**From:** [Kelly Bacon](#)  
**To:** [Dusty Pilkington](#)  
**Cc:** [Lucas Huck](#)  
**Subject:** RE: CB-16-00005 Defoor  
**Date:** Friday, August 26, 2016 9:57:37 AM

**From:** Dusty Pilkington  
**Sent:** Friday, August 26, 2016 9:45 AM  
**To:** Lucas Huck; Holly Duncan; Holly Myers; Kelly Bacon; Josh Hink  
**Subject:** CB-16-00005 Defoor

DEFOOR PROPERTY

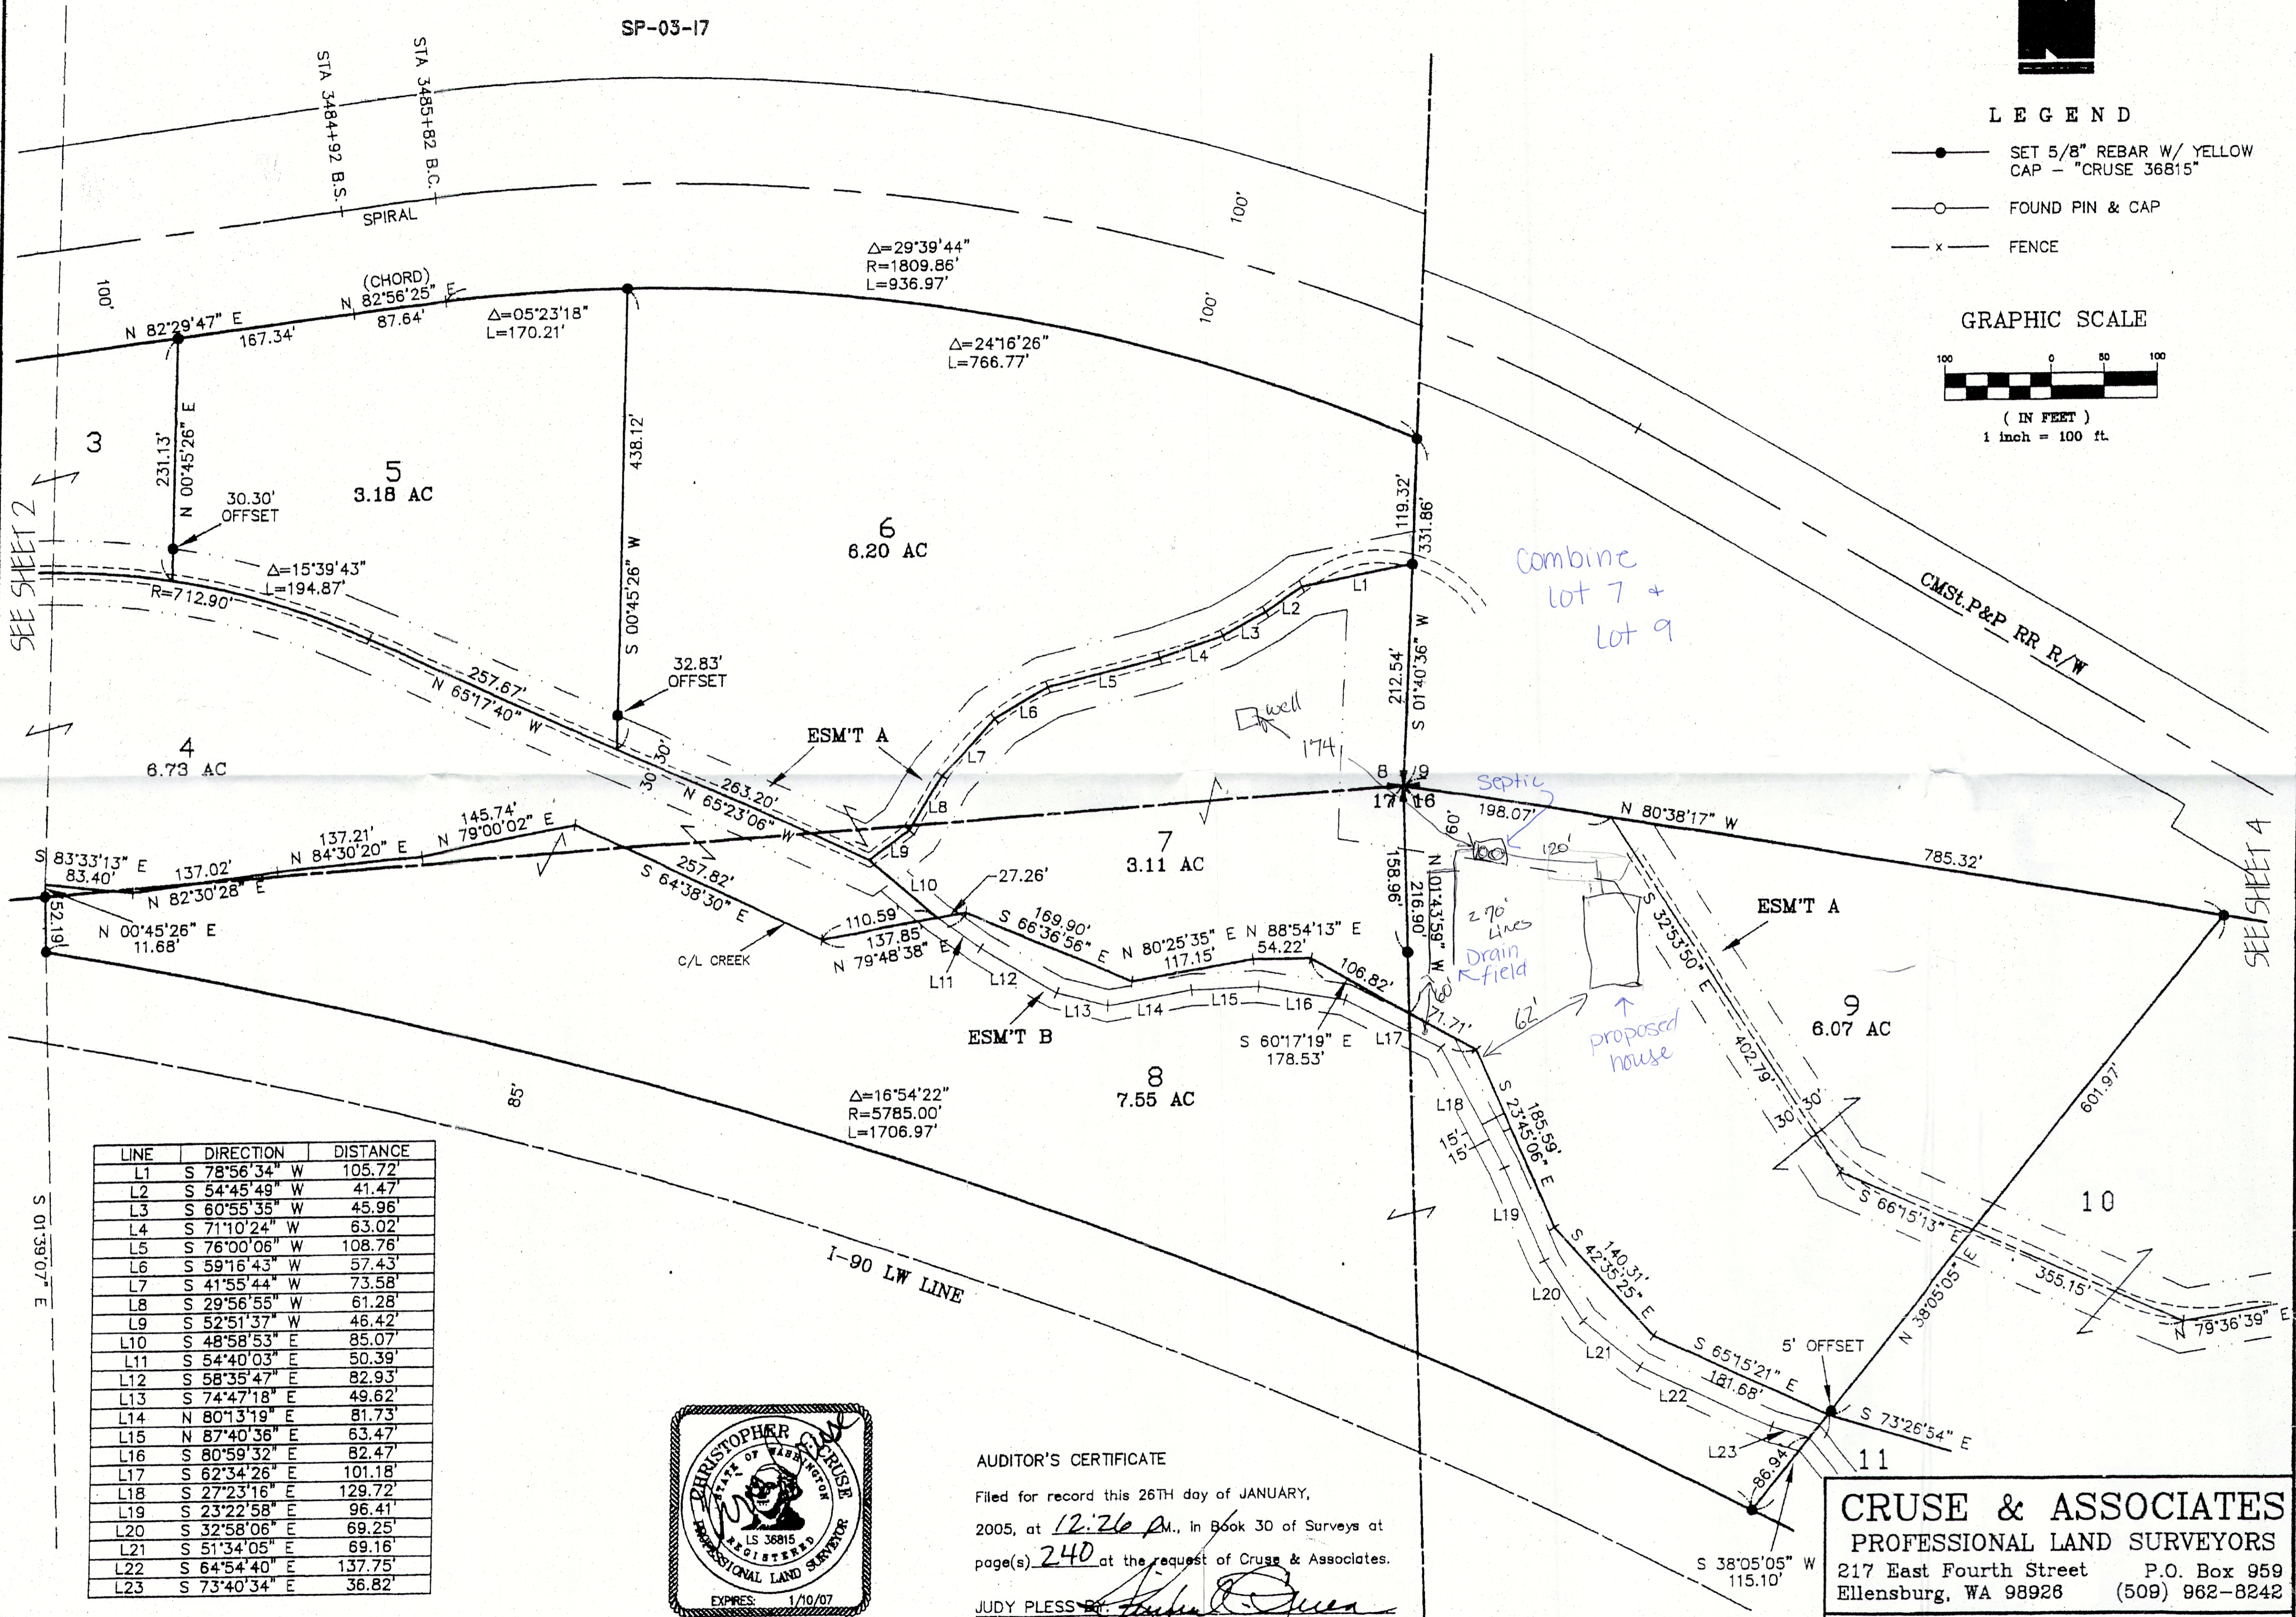
Public Works has reviewed this parcel combination. The only comment that I have is the site map attached is showing the proposed residence located within the 60' access easement. Other than this observation, I have no comments.
